CITY OF ALBUQUERQUE

**RE: McDonalds – Coors and Hanover
1501 Coors Blvd NW
Request for Certificate of Occupancy – 60 day Temporary
Hydrology Final Inspection - Approved
Engineer's Stamp Date 4/5/17 & 8/23/17 (J11D037)
Certification Dated: 12/19/17 & 12/21/17**

Based on the certification received 12/20/17, this submittal is approved for release of Certificate of Occupancy (60-day Temporary) by Hydrology. Prior to Engineer's Certification for Permanent Certificate of Occupancy, the following must be corrected:

C8.1

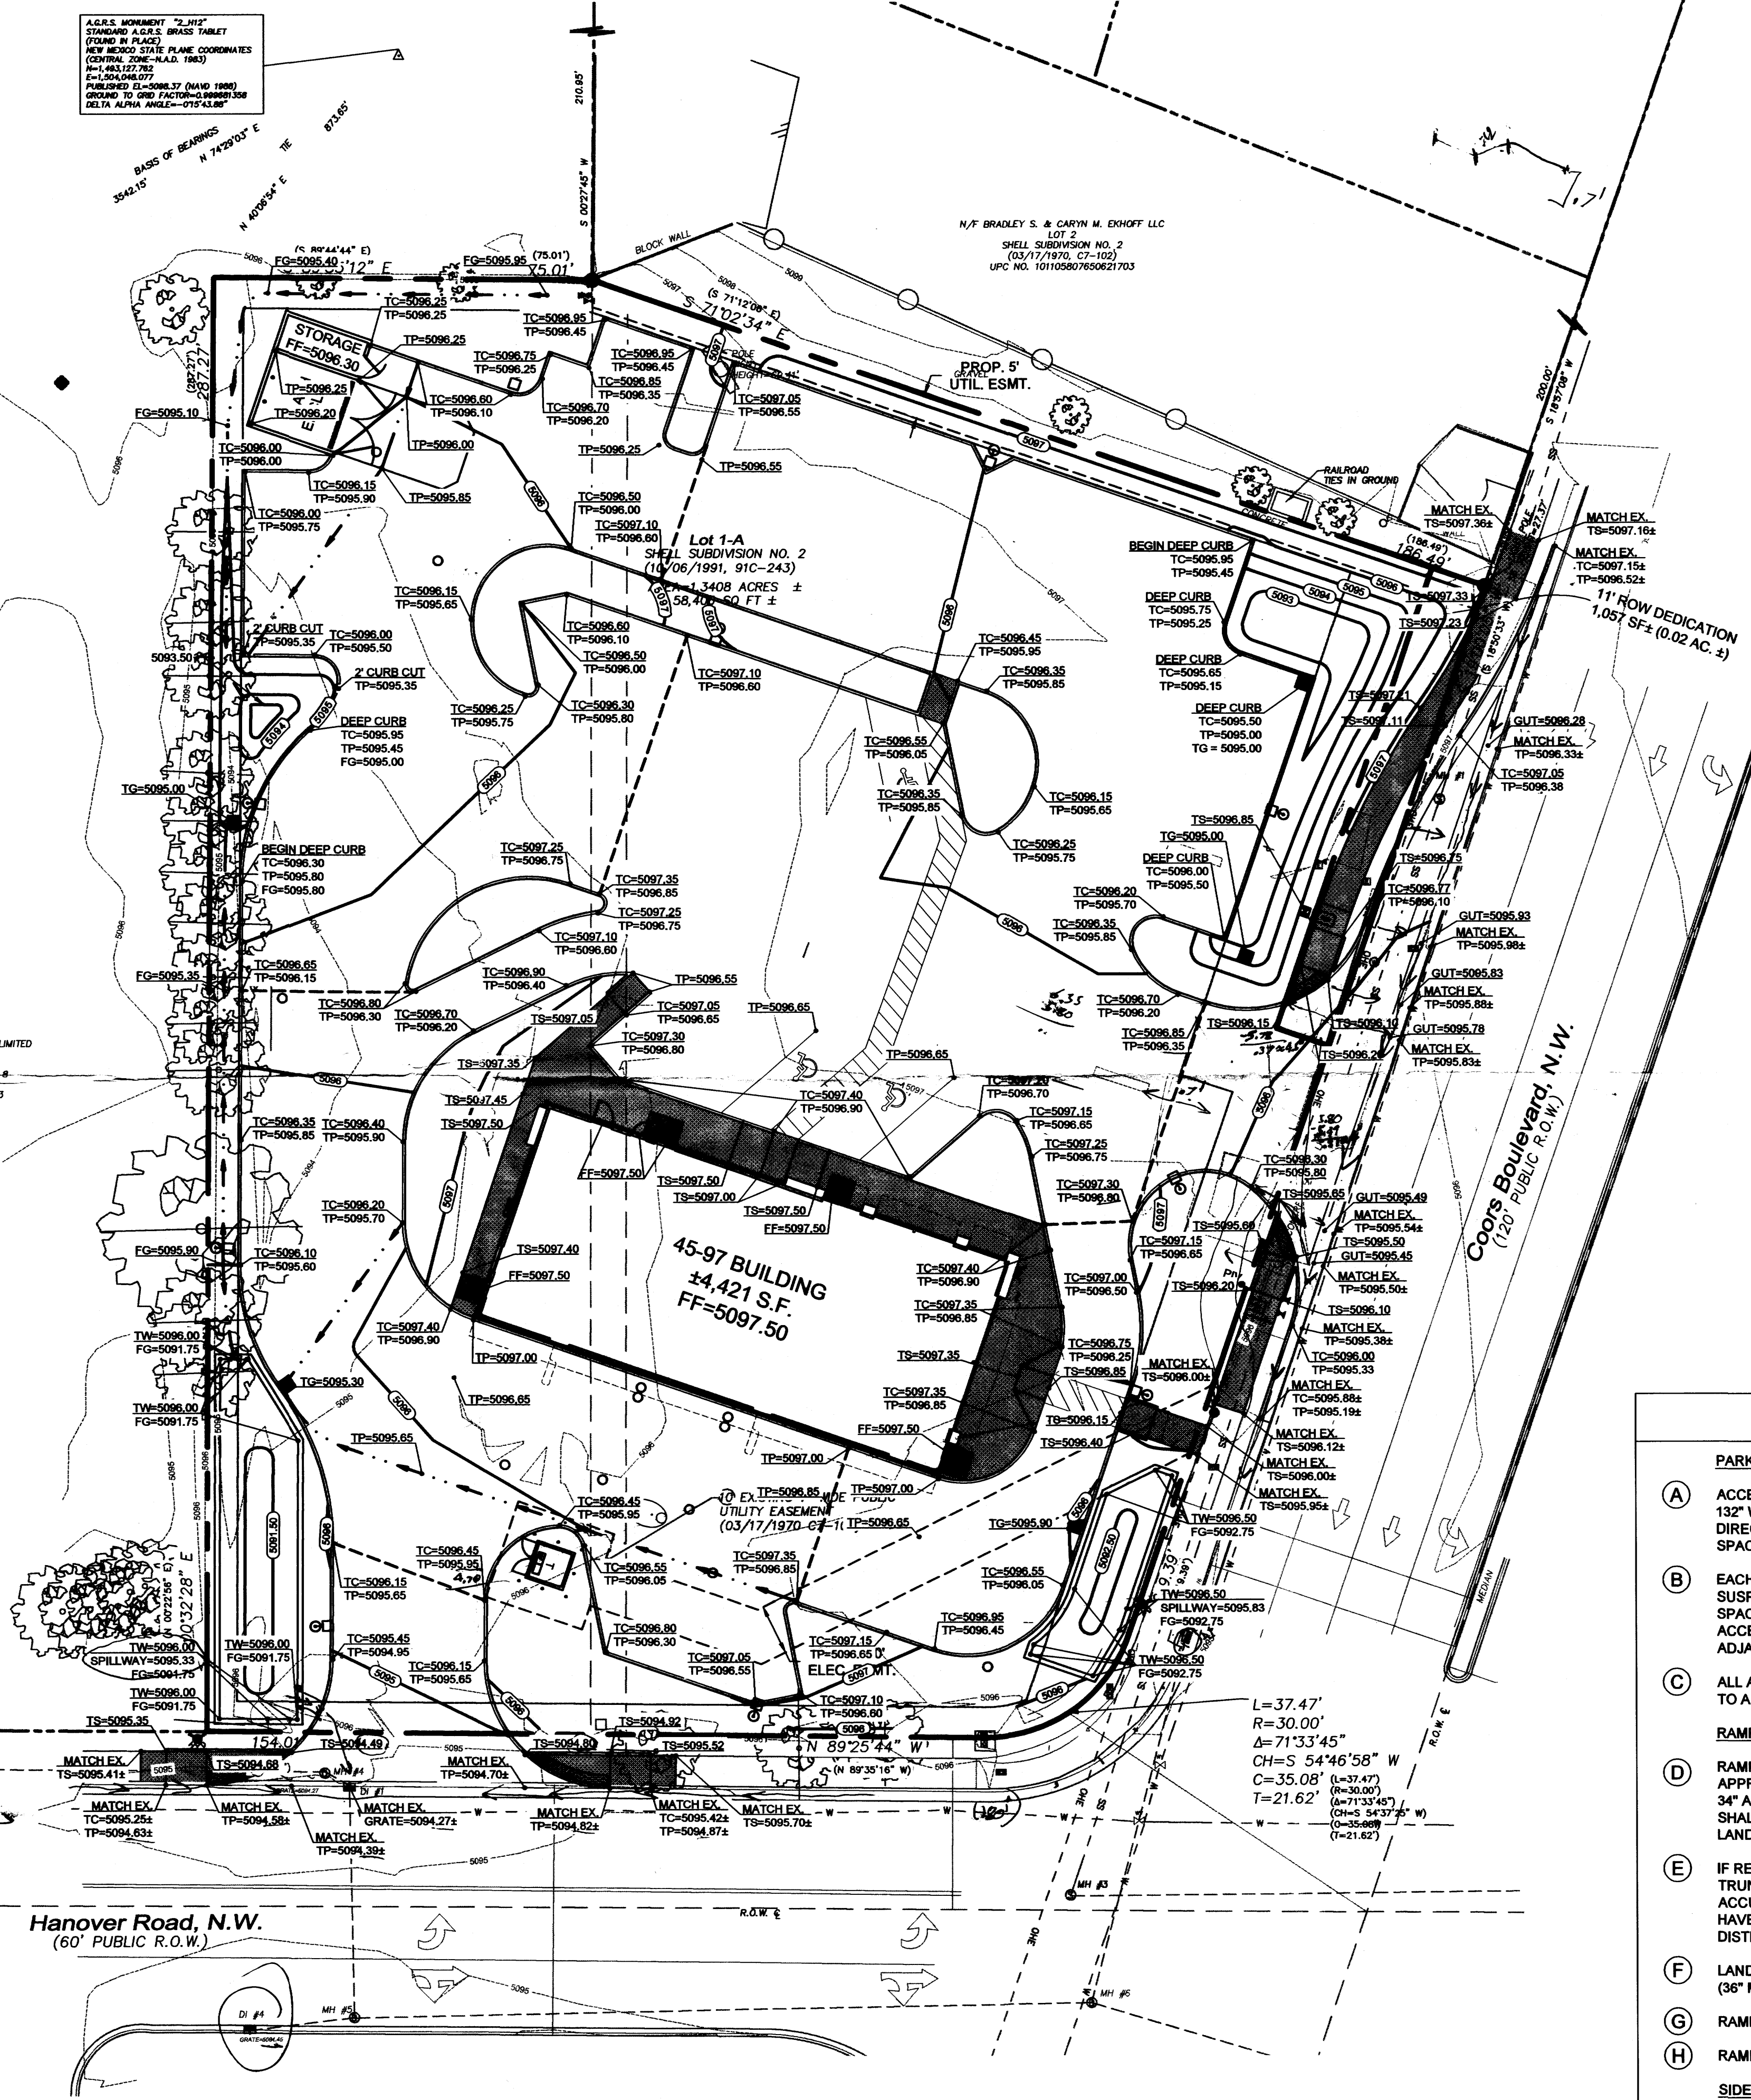
1. A \$25 check, payable to City of Albuquerque, is required for recording the Drainage Covenant. Please provide this to Madeline Carruthers (mtafoya@cabq.gov, 924-3997) or Charlotte LaBadie (clabadie@cabq.gov, 924-3996) in DRC-Construction Services (4th Floor, Plaza del Sol).
2. The Bernalillo County Recorded Drainage Covenant will need to be provided with the drainage certification. DRC-Construction Services will record the Covenant; please ensure Hydrology receives a copy as well.
3. A new Drainage Certification of the Grading and Drainage Plan (C7.0 and C8.1), with a new certification date will need to be provided for requesting permanent C.O.
